**From:** Laura Gibbons <[Laura.Gibbons@arun.gov.uk](mailto:Laura.Gibbons@arun.gov.uk)>  
**Sent:** 16 November 2020 12:01  
**To:** Planning.Responses <[Planning.Responses@arun.gov.uk](mailto:Planning.Responses@arun.gov.uk)>  
**Cc:** Simon Davis <[Simon.Davis@arun.gov.uk](mailto:Simon.Davis@arun.gov.uk)>  
**Subject:** P/97/20/PL- Land To North Of Summer Lane Pagham

#### Engineers Comments On Surface Water Drainage

We wish to raise a holding objection at this time.

Drawing Title
Proposed Site Plan
105 Unit Scheme

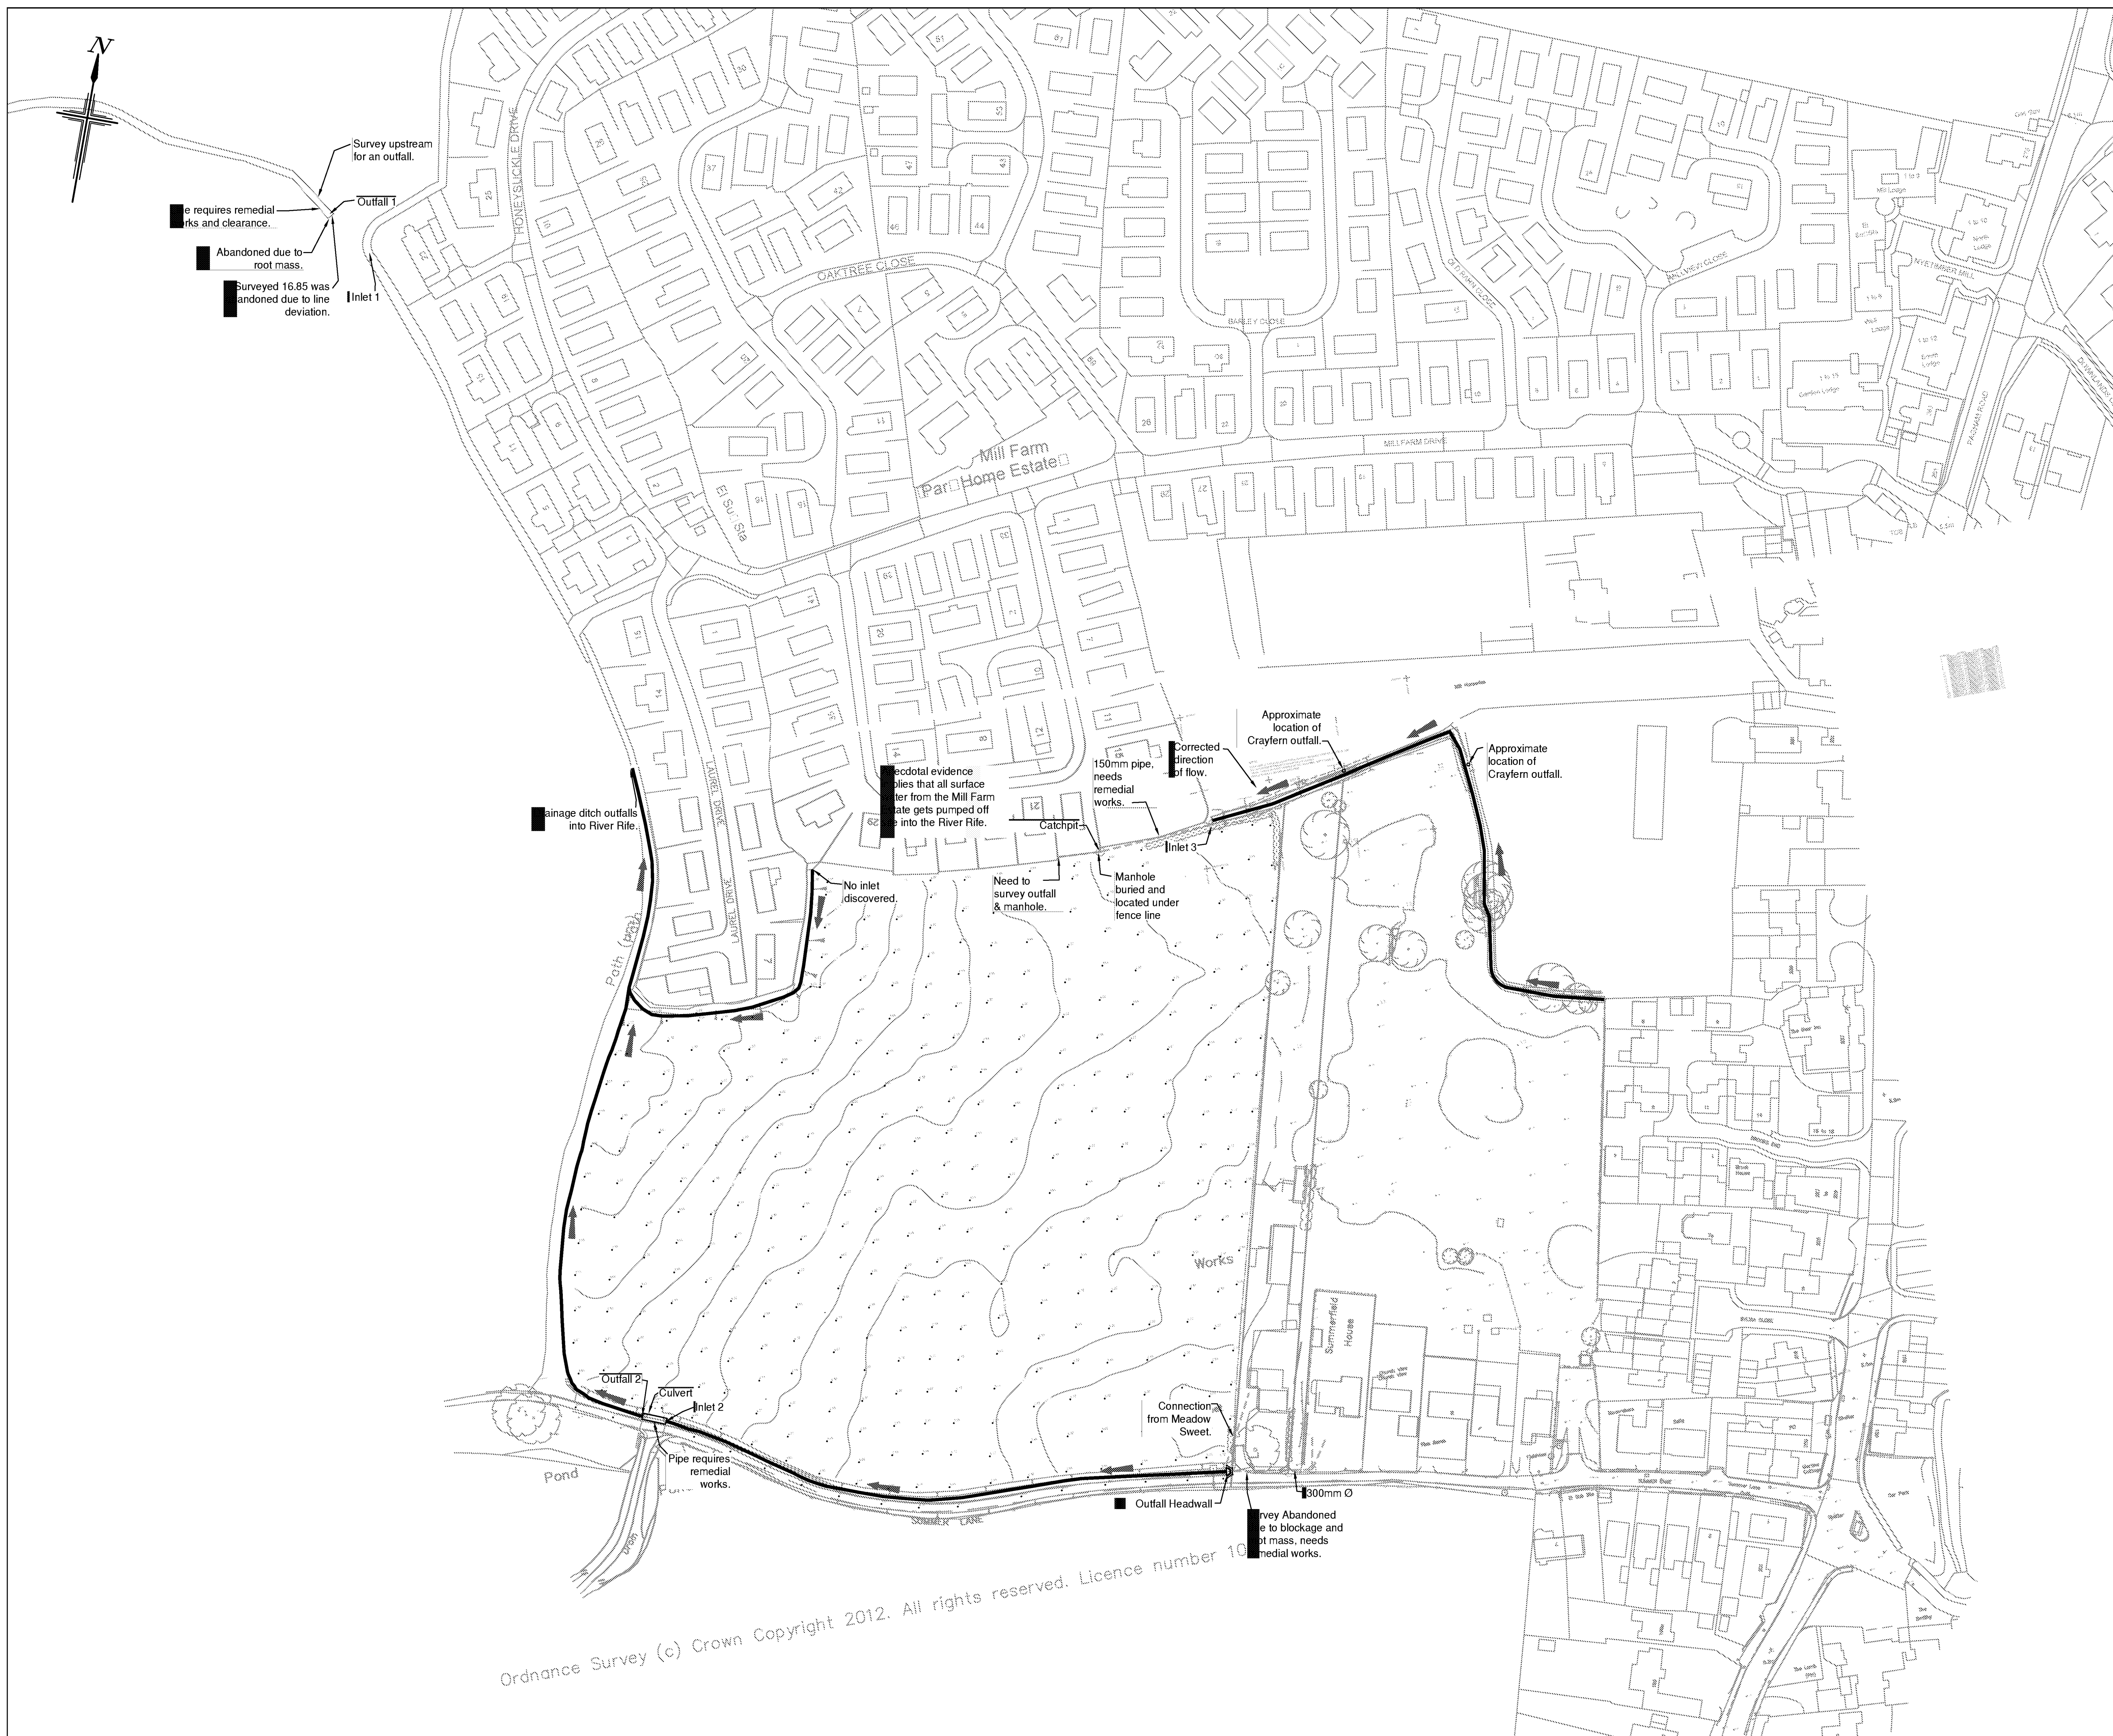
The proposed revised plans will result in an increase in ditch crossing points. A matter that we raised on the original proposals. We believe that the increased crossings will lead to a deterioration in the condition of the watercourse. Loss of daylight, loss of habitat and significant restrictions upon access for maintenance will likely result in ecological detriment and an increase in flood risk. We therefore do not support this proposed change in plan and would request that the number of ditch crossings is reduced.
